Subject: Retail Ranch Filing No. 1 – 2nd Review

The purpose of this letter is to respond to review agency responses to the above named development application. Responses to comments are shown in **RED** below the agency comment.

GRADING & EROSION CONTROL PLAN

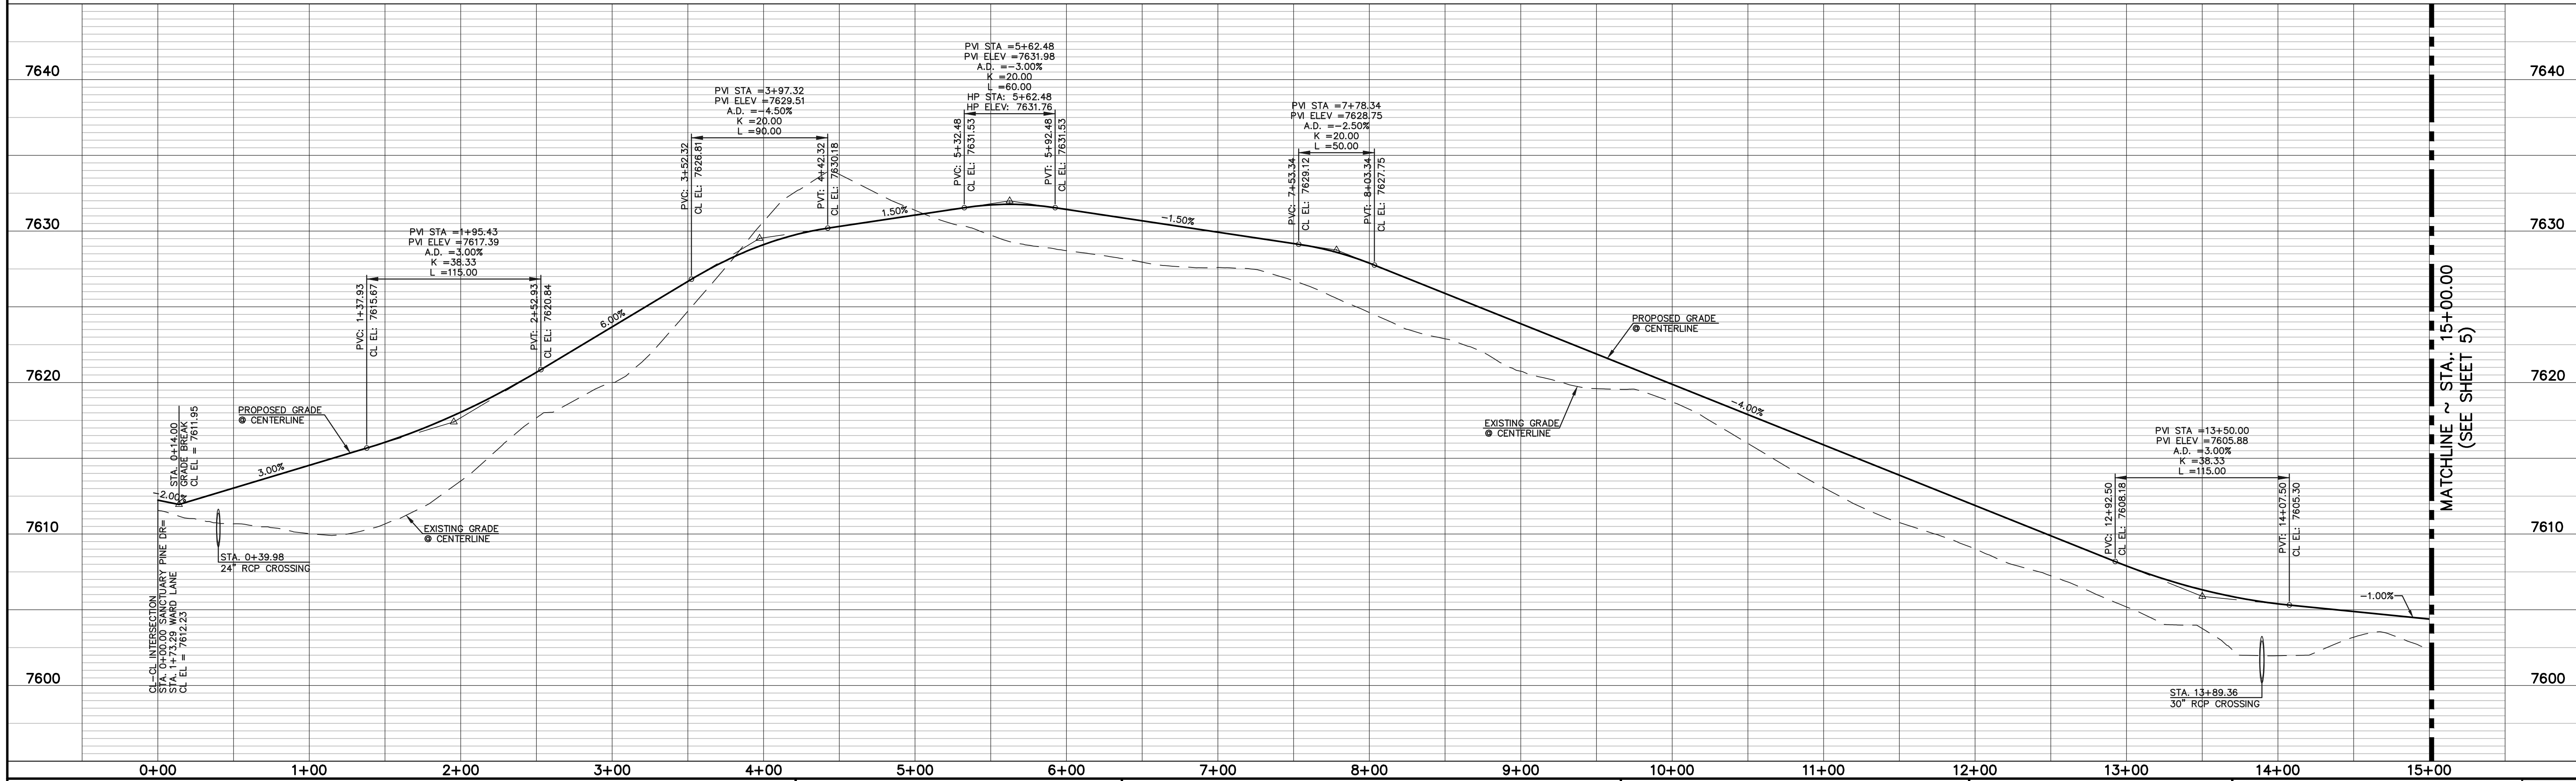
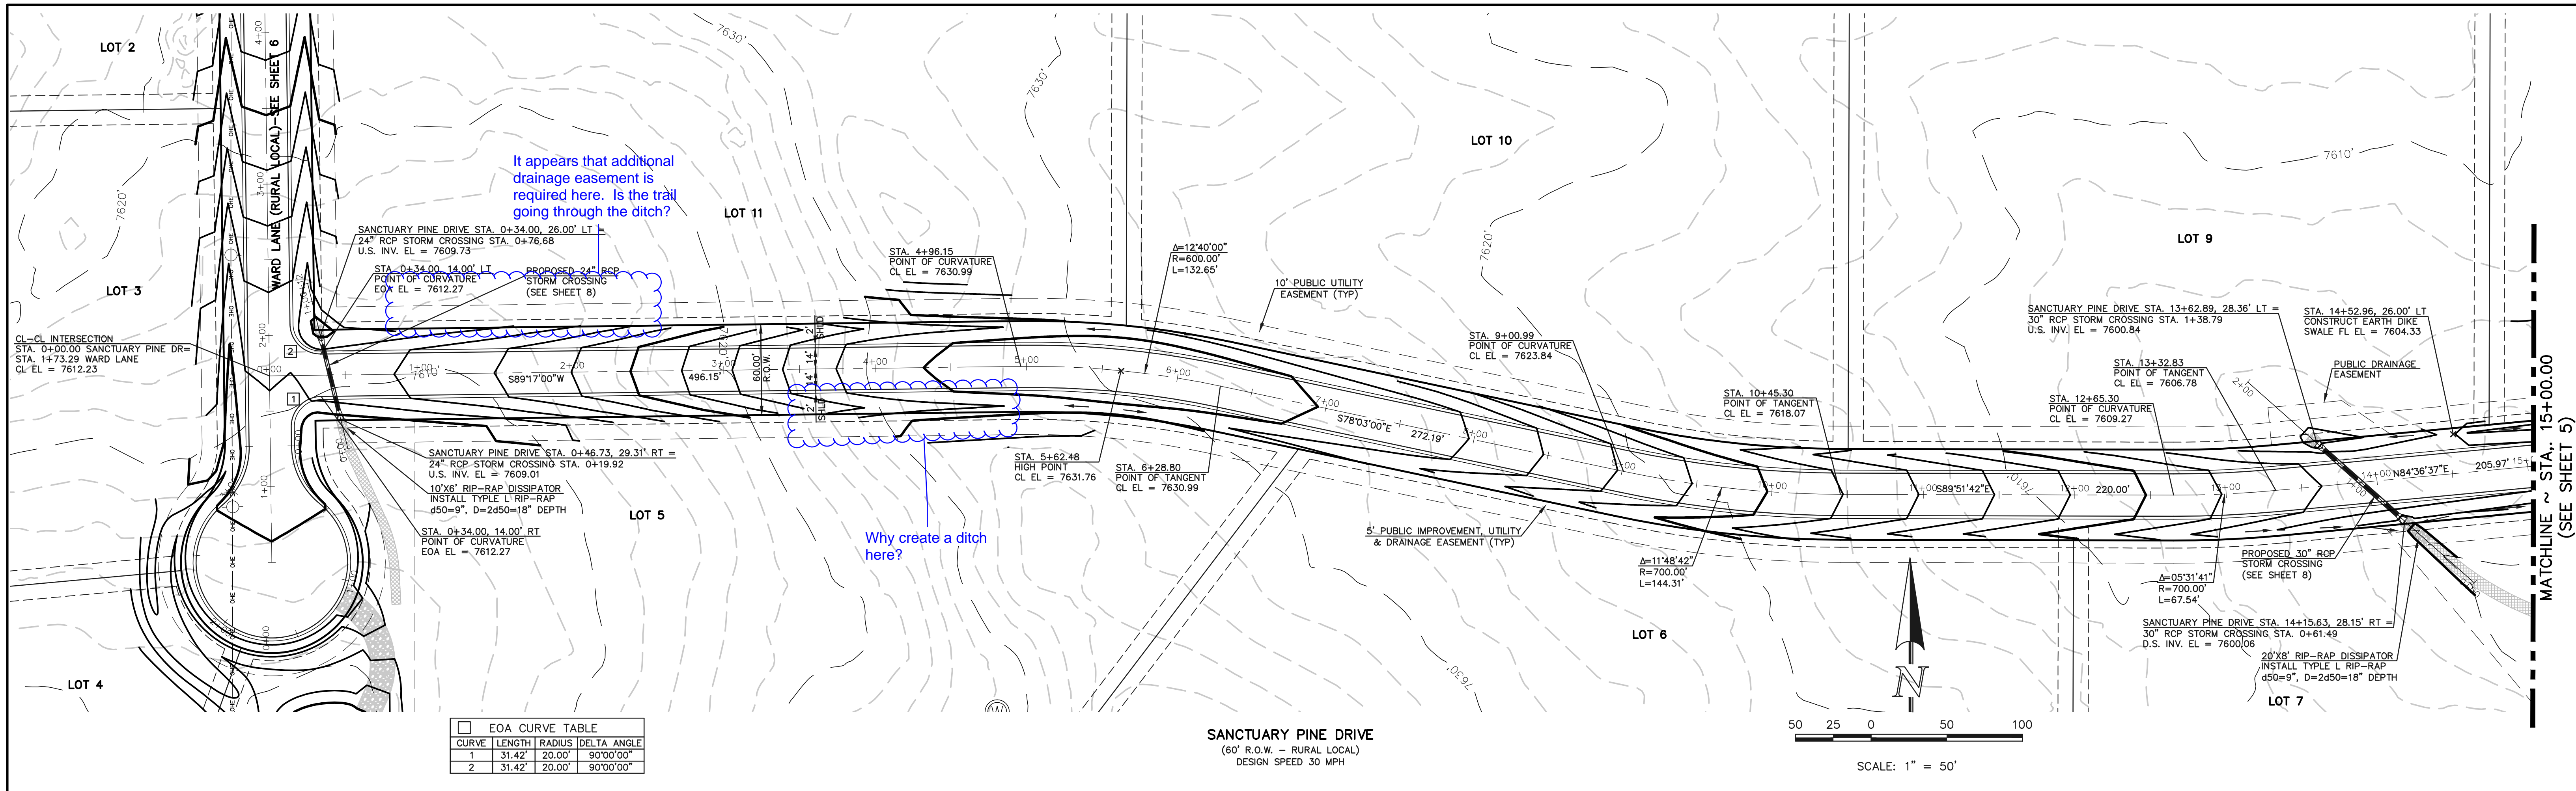
1. Provide sediment basins (temporary and permanent) at all necessary locations. **Partially resolved; permanent sediment control is required for the proposed road area (Sanctuary Pine Drive) draining to Vollmer Road without going through Pond 2. Provide BMPs upstream of the proposed Vollmer Road ROW. See additional design on revised plans**

SANCTUARY PINE DRIVE
(60' R.O.W. - RURAL LOCAL)
DESIGN SPEED 30 MPH

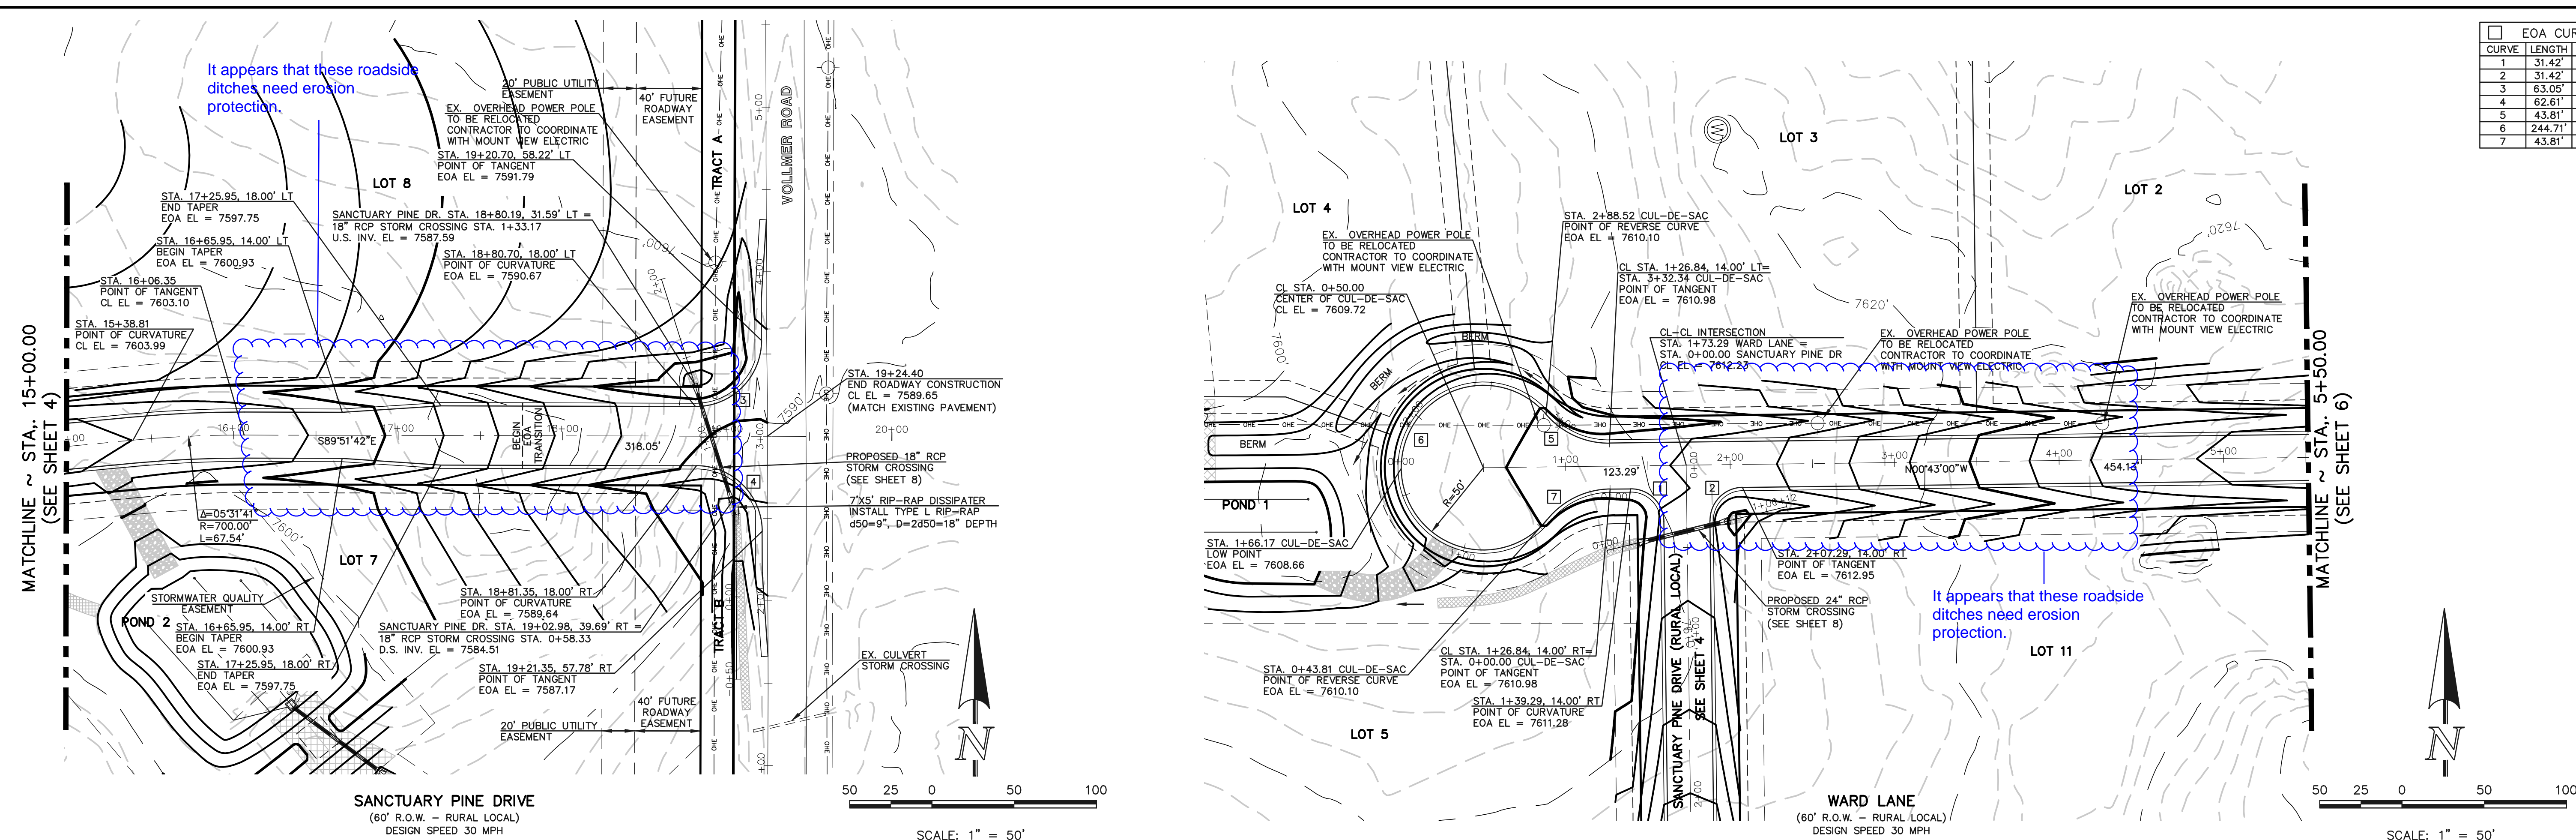
- a. Downstream emergency overflow paths. **Partially resolved; see redlines. Addressed. See revised plans**
 - b. Ditch line capacities. **Unresolved. See additional info. in revised report**

- c. Ditch line velocities and erosion control. **Unresolved. See additional info. in revised report and on revised plans**
6. Geotechnical issues:
 - a. Provide the necessary additional geotechnical study for final design as recommended in the report, if applicable. **Partially resolved; see next comment.**
